14 January 2019

Kent and Essex Inshore Fisheries and Conservation Authority
Paragon House
Albert Street
Ramsgate
Kent
CT11 9HD

Application for a Development Consent Order – Thanet Extension Offshore Windfarm

Figure 2.6: Proposed cofferdam layout for open trenching cable installation. If option 2 is taken forward the sea defence would be extended seawards by a maximum of 18.5 m. If option 3 is taken forward the sea defence would remain in its existing position.

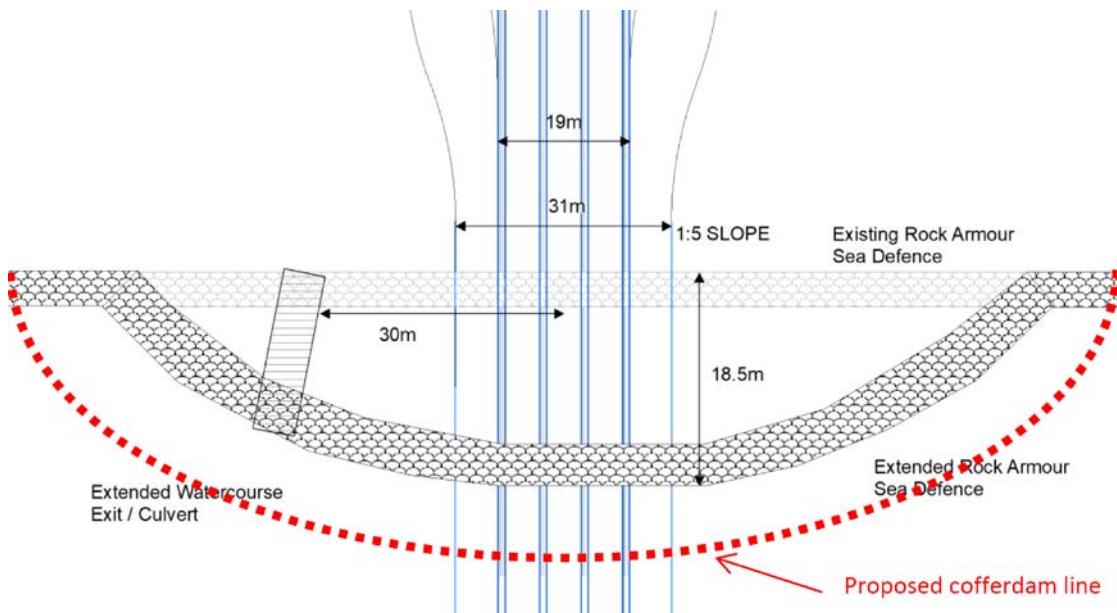
KEIFCA disagree with this conclusion set out in section 5.11.19 of the ES volume 2. The extension of the sea wall will cut across the saltmarsh habitat at its narrowest point. The Environmental Statement (ES) does not provide any further information regarding the potential for local erosion as a result of the sea wall extension which could cause separation of the habitat.

KEIFCA would like to see supporting evidence regarding the potential for further impacts of local erosion as a result of the sea wall extension.

In addition, the installation methodology for the export cable also raises concerns. KEIFCA deem Option 1 provided in the Saltmarsh Mitigation, Reinstatement and Monitoring Plan to be the less damaging provided appropriate mitigation measures are implemented during construction. This option should, therefore, be given priority.
